Ribble Valley Borough Council
Church Walk,
Clitheroe,
BB7 2RA

Phone: 0300 123 6780
Email: lhscustomerservice@lancashire.gov.uk
Your ref:
Our ref: LHS/CS/3/2016/0775
Date: 6th October 2016

Proposal:	Replacement kitchen extension
Location:	Pages Farm Wood House Lane Slaidburn BB7 3AH
Grid Ref:	370340 - 452732

Ground Floor Plan

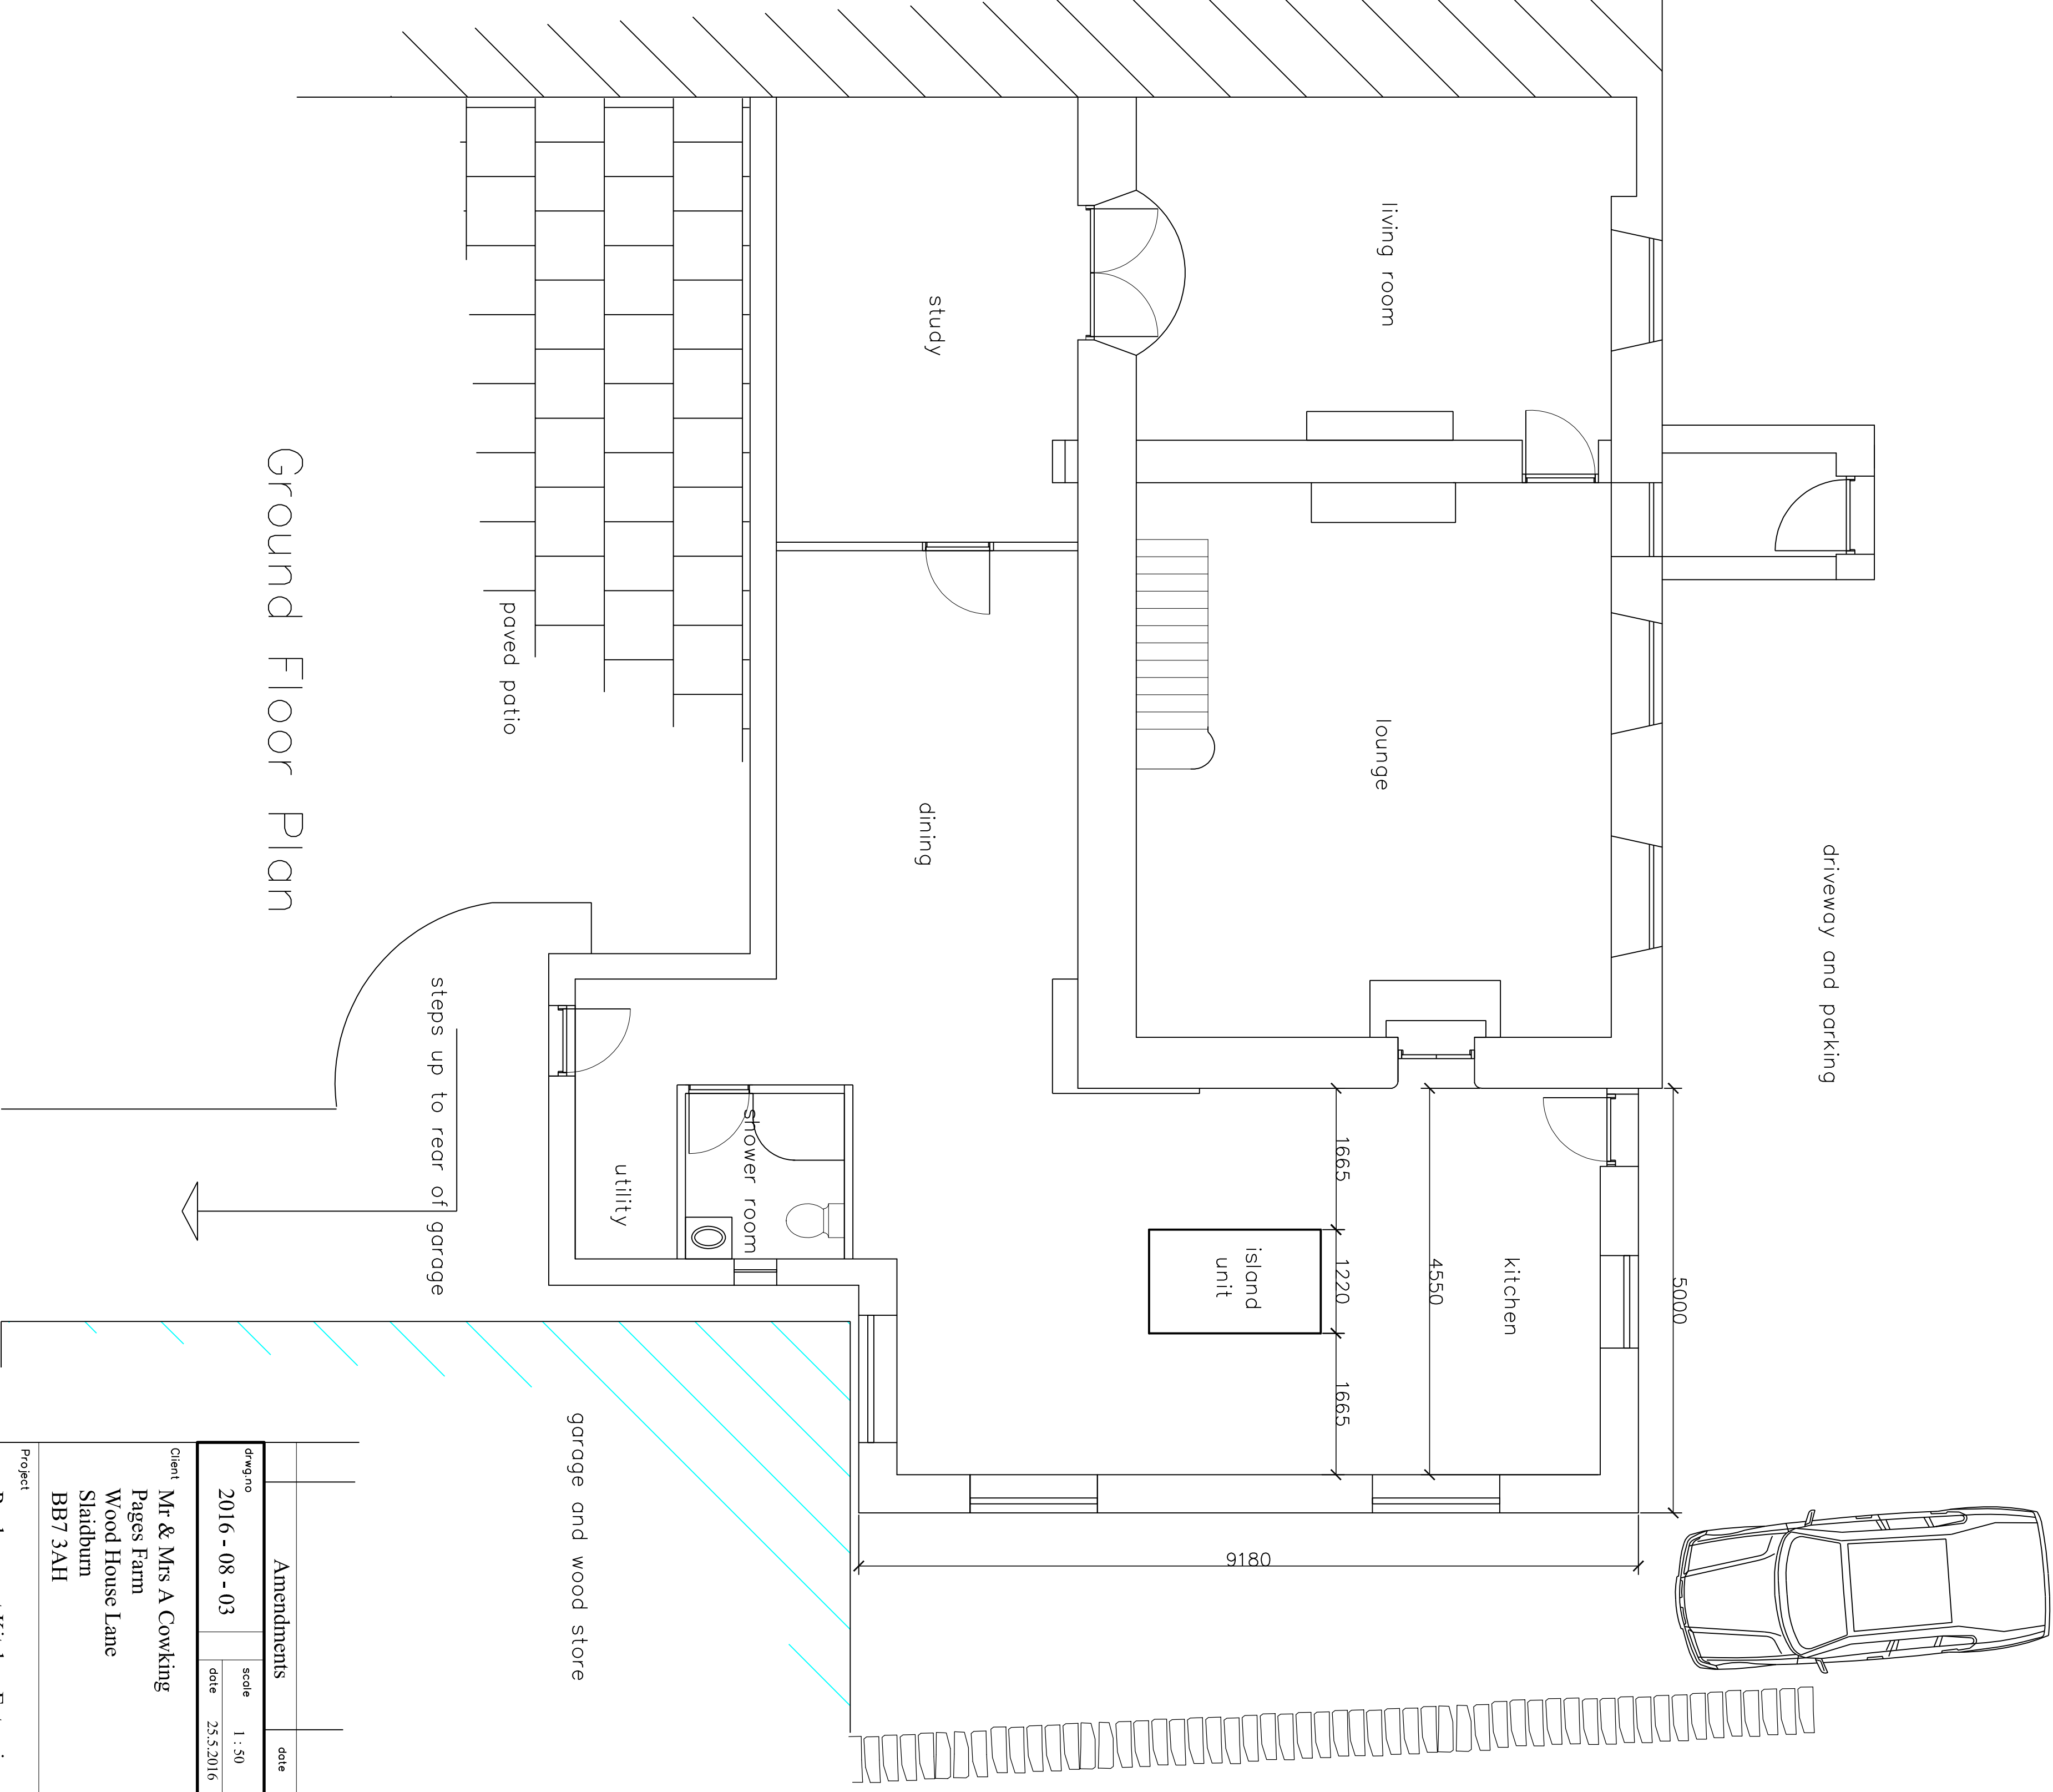
The Highway Development Control Section does not have any objections in principle to the proposed kitchen extension providing three off road car parking spaces can be provided without affecting the manoeuvring and parking spaces for the adjacent properties, to reduce the effect on the local amenity for the adjacent properties.

The proposed extension will prevent vehicle movement to the existing garage and also remove 1.5 car parking spaces.

Based on the car parking recommendations in the Joint Lancashire Structure Plan and the Ribble Valley Parking Standards, the Highway Development Control Section is of the opinion the applicant should provide three off road parking spaces for a 4 bed property, one of the rooms is shown as a study although it is capable of taking a double bed. The applicant should provide accurate details of the car parking and manoeuvring area, before determining the application and the parking must be within the land ownership of the applicant

The recommended minimum dimension for a parking bays to be 2.4m wide by 5.0 m long and a 900mm clear passage for pedestrians to access the front door is required, (Part M of the approved documents) The reduced car parking may affect the safe manoeuvring of farm vehicles and private cars to adjacent properties and also affect the amenity for the adjacent properties.

1. The car parking and manoeuvring scheme to be marked out in accordance with the approved plan, before the use of the premises hereby permitted becomes operative and permanently maintained thereafter. Reason: To allow for the effective use of the parking areas.
